Recommendation Report for Planning Permission for Works or Extension to a Dwelling

REF NO: FP/74/20/HH

LOCATION: 12 Outerwyke Road
Felpham
PO22 8HX

PROPOSAL: Single storey rear extension & alterations.

Proposed Elevations

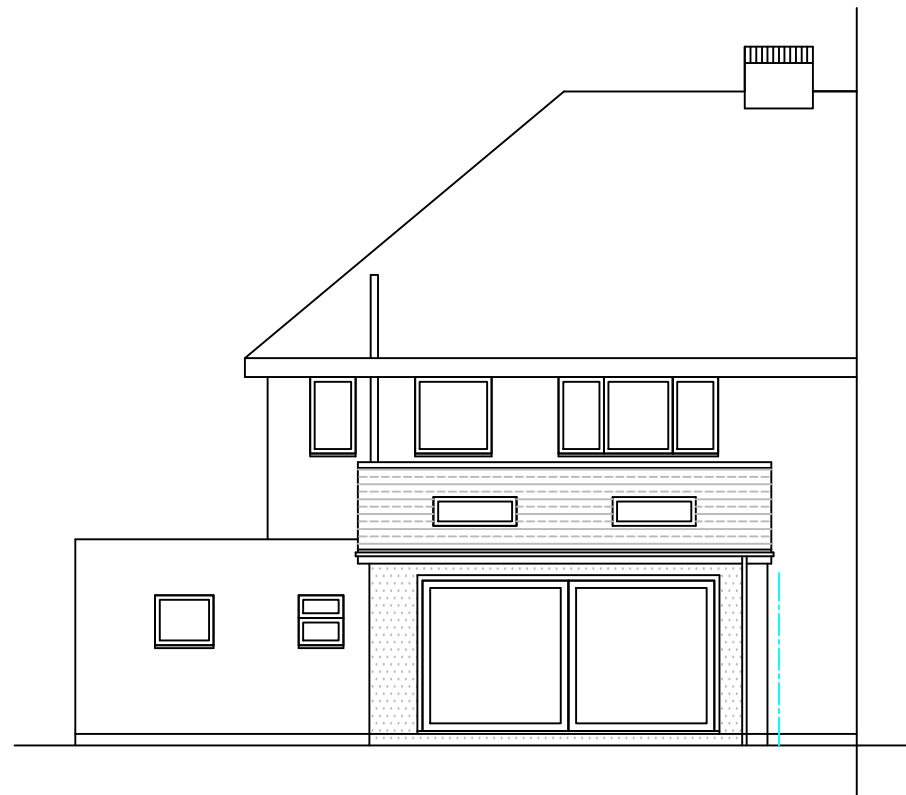
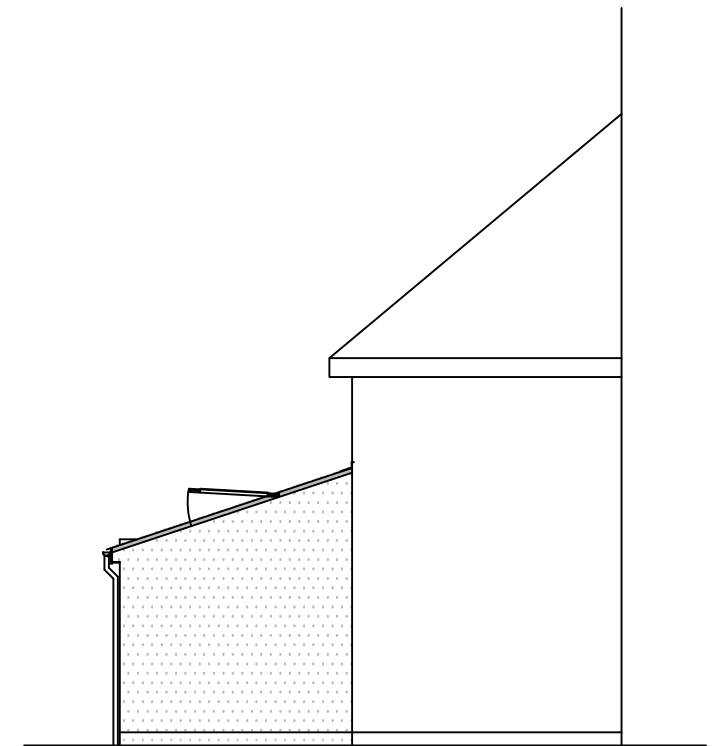
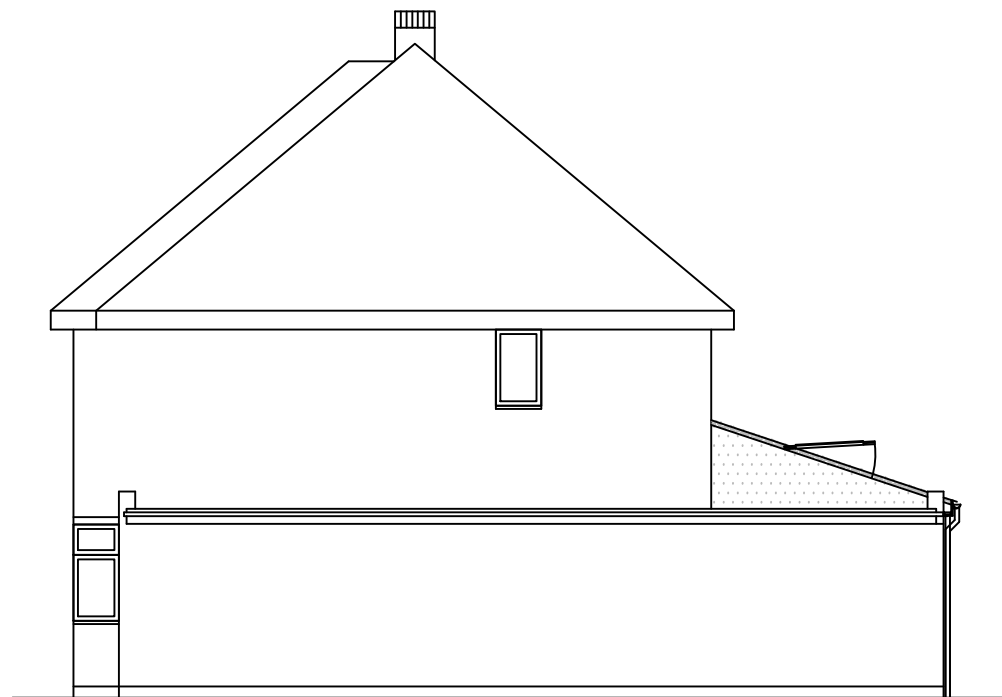
The extension will be single storey and appear well integrated with the host dwelling. There is an existing conservatory which the extension will replace. The extension has a lean to roof and extend along the rear elevation meeting with the garage to the western elevation.

The extension will have a depth of 3m. It will have a height of 3.75m with eaves to 2.5m.

Views will be of the rear garden with no side windows proposed.

Existing & Proposed Ground Floor Plans

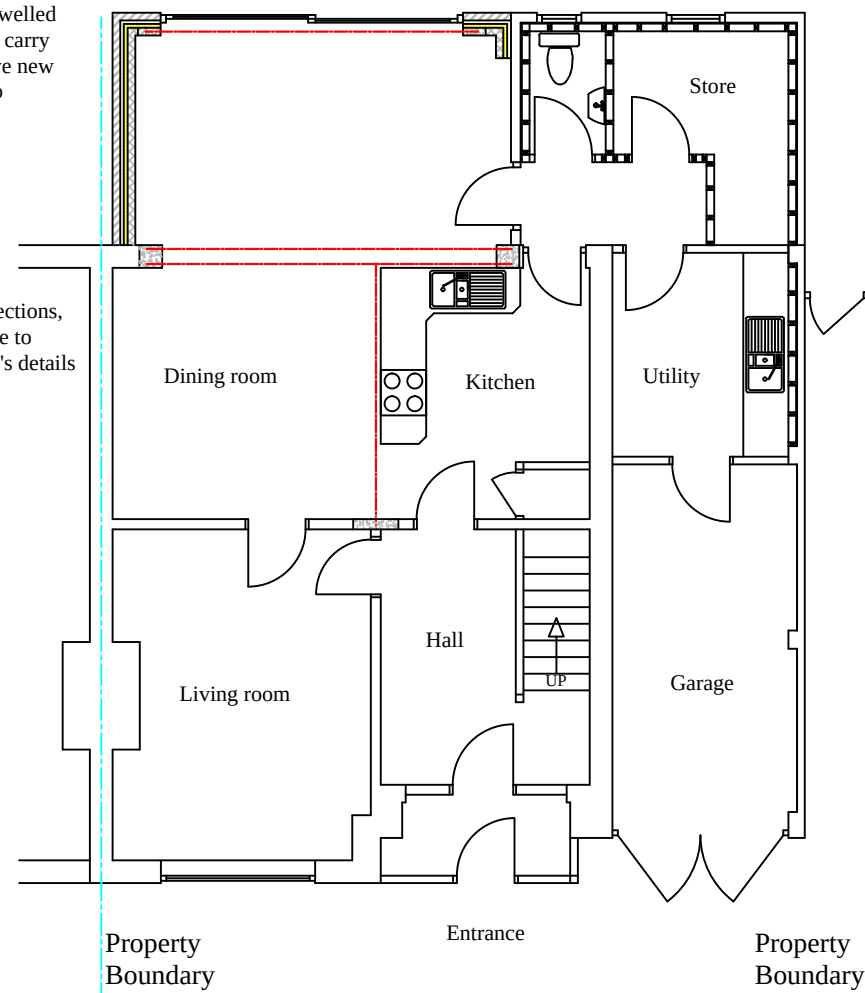
This extends to the same depth as the neighbouring property at No.14 and is not considered to result in adverse impacts on amenity. The neighbouring property has a conservatory at the boundary however due to the design and size of the extension which is similar to an existing conservatory in place at the host dwelling it is not considered to give rise to additional adverse impacts.
